OXFORDSHIRE COUNTY COUNCIL'S RESPONSE TO CONSULTATION ON THE FOLLOWING DEVELOPMENT PROPOSAL

Application no: 21/03177/F

Proposal: Axis J9 Phase 3 Howes Lane Bicester

Transport Development Control

Phase 3 External Works & Levels 1:1000

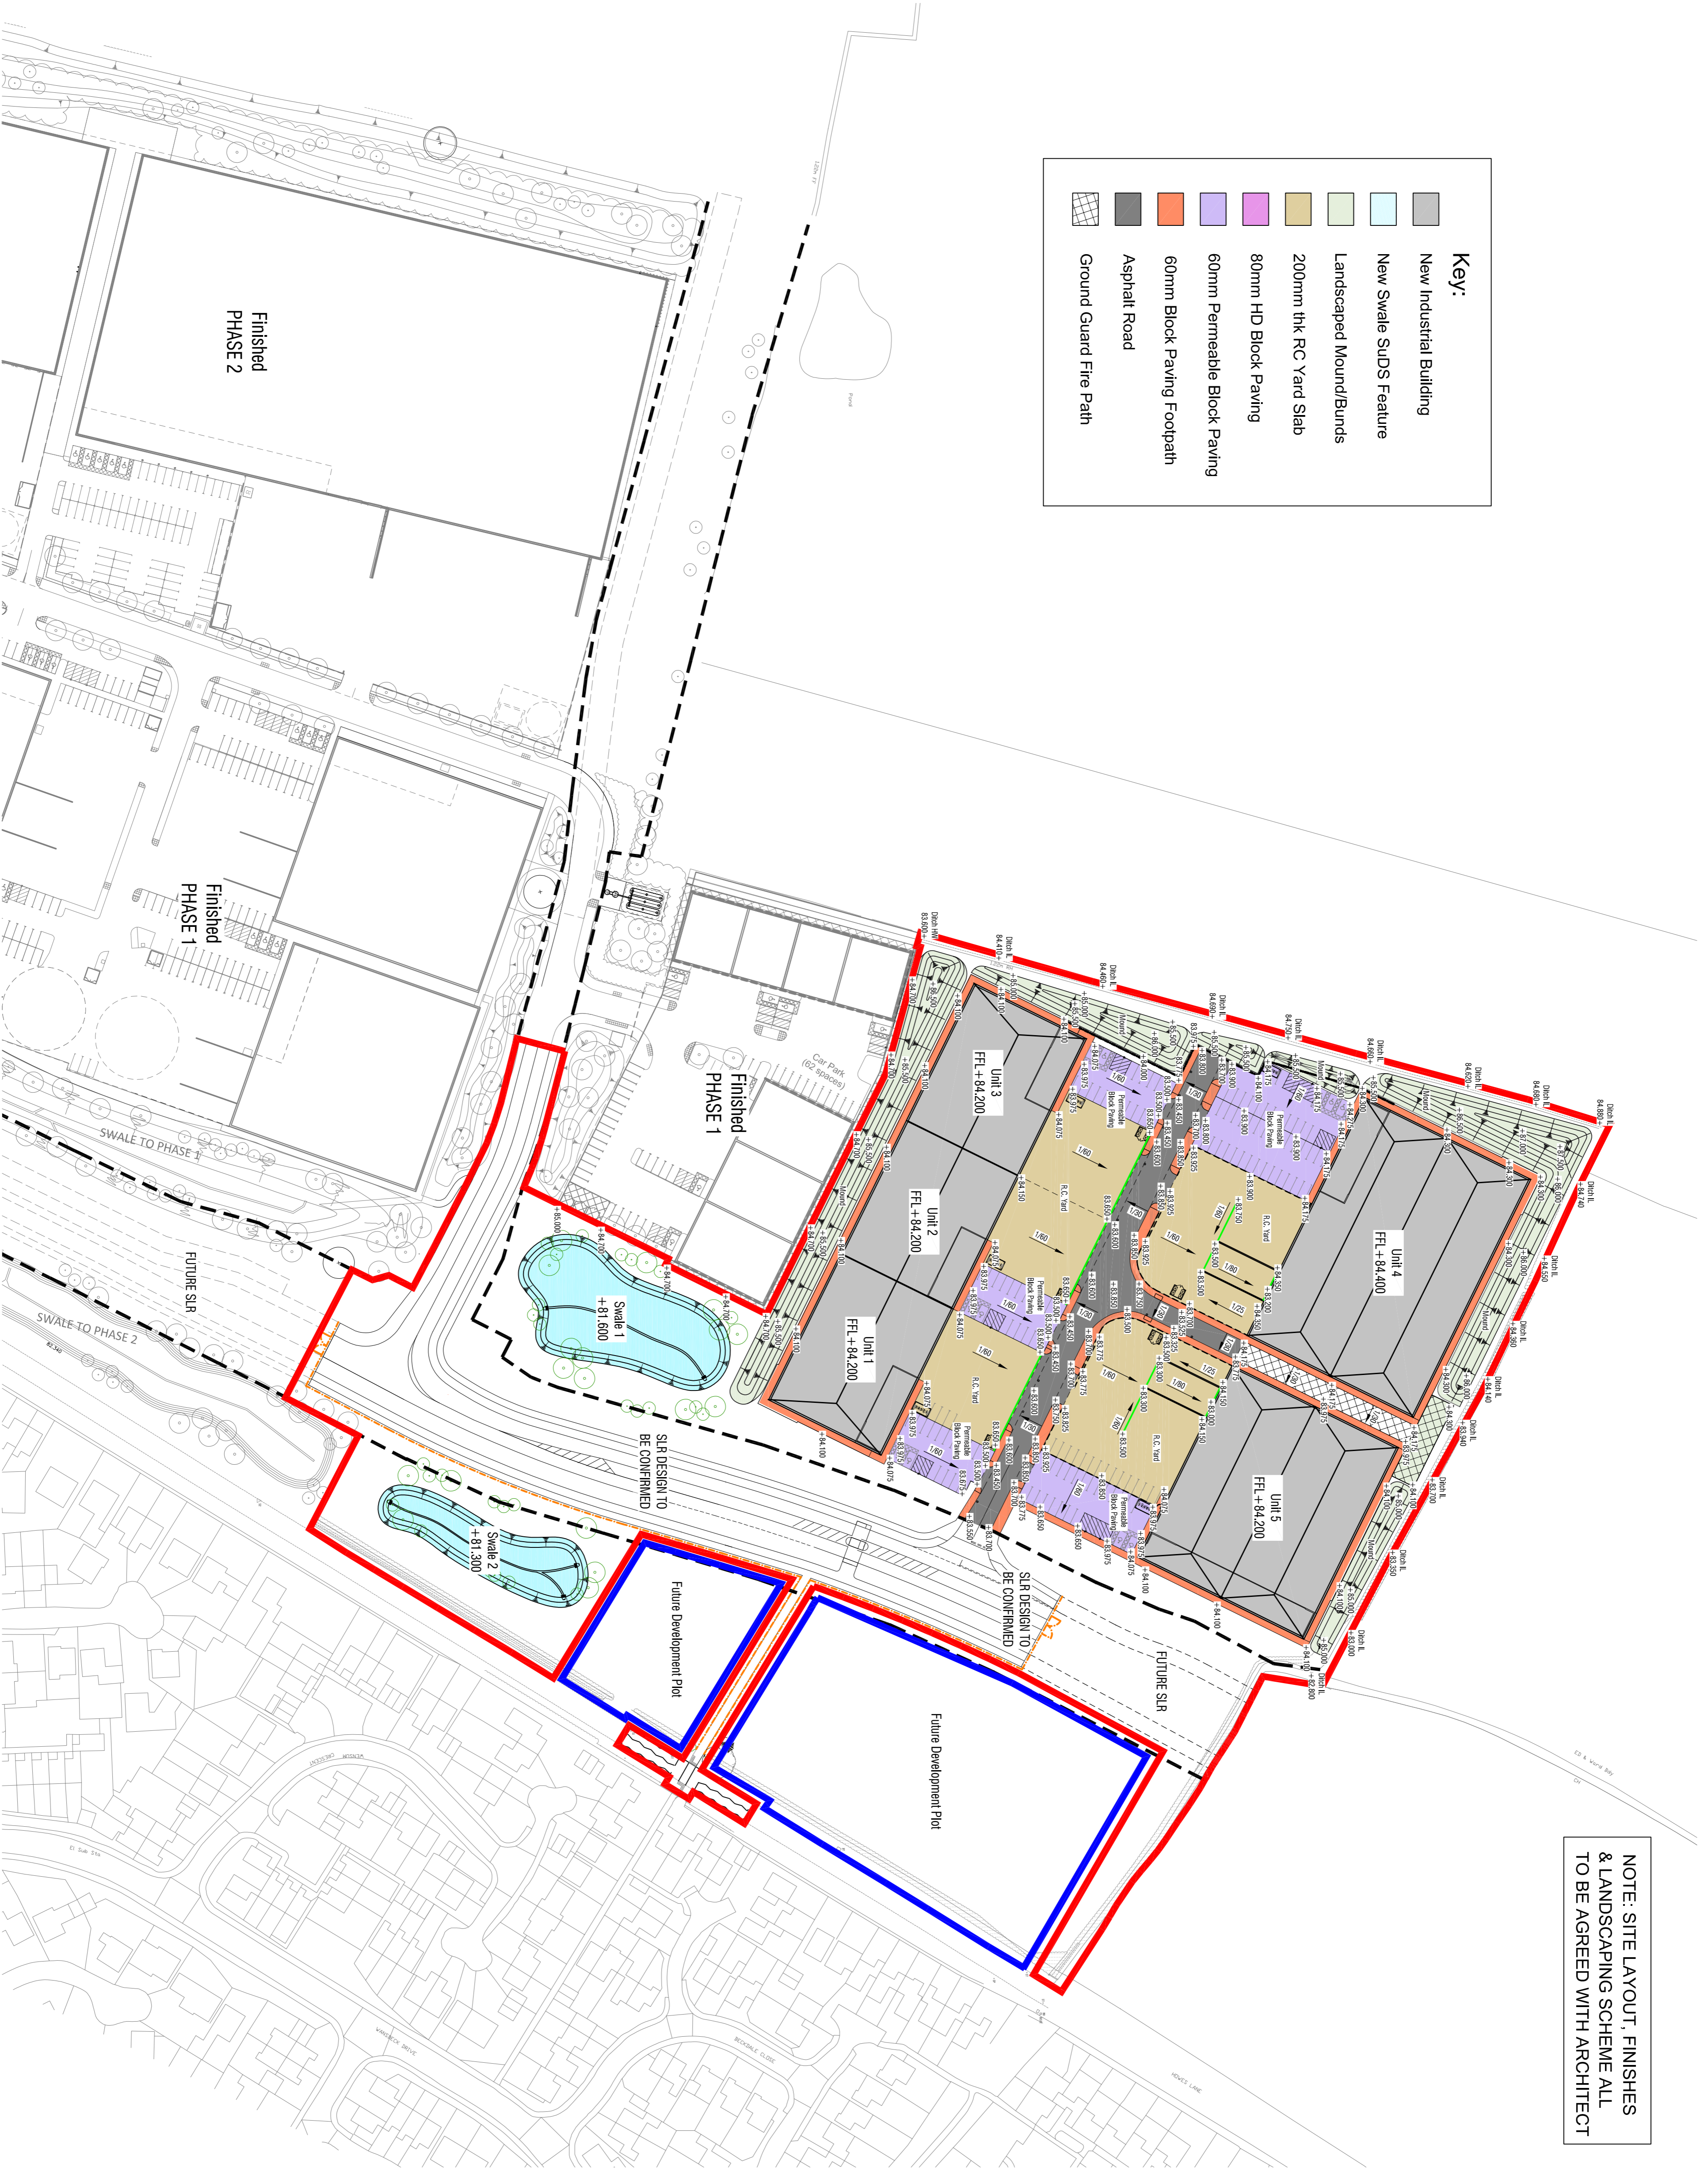
A 4.0m shared use footway/cycleway would be provided on the northern side, and a 2.5m cycleway and 2m footway on the south side, separated from the carriageway by a 5m verge. 2.5m cycleway is the 'absolute minimum at constraints' for two-way cycling as set out in LTN 1/20. 4m shared use is not compliant with LTN 1/20. Whilst these dimensions meet with the cycle/pedestrian facilities in the approved planning permission for the SLR (ref 14/01968/F) as described in section 4.3 of the Transport Assessment), policy has changed since that permission was granted, and the facility must now be compliant with LTN 1/20. Whilst priority for cyclists is provided across the access junctions, a pedestrian crossing point is missing from the access into the eastern parcel. Given the length of the crossings, consideration should be given to providing a refuge.

Further, the road infrastructure in the area circled yellow below will form part of the permanent road infrastructure linking units 8 to 14 to the SLR and must be designed to

The site plan shows an access road leading east through the eastern parcel, ending at a gate. A pedestrian/cycle connection should be made here to Howes Lane, in the interest of providing a range of sustainable transport modes and of highway safety. The absence of a connection is a reason for objection, even in the interim situation, which could last many years.

Within the parcels, pedestrian priority should be provided across the accesses into each unit.

Following completion of the SLR, the site would be on the future NW Bicester bus route. However, no bus stops are shown on the plan. These could potentially be accommodated on the road between Phases 1 and 2, but this needs to be demonstrated, and bus stop and shelter provision needs to be taken account of in the design. In accordance with LTN 1/20 a cycle bypass would be required for the shelter, which needs to be accommodated in the design.

Unable to find plan showing the exceedance flood routes.

As this is a full application, we expect to have definite indication of all SuDS that will be installed as part of the development. Where SuDS cannot be implemented, valid justification must be provided.
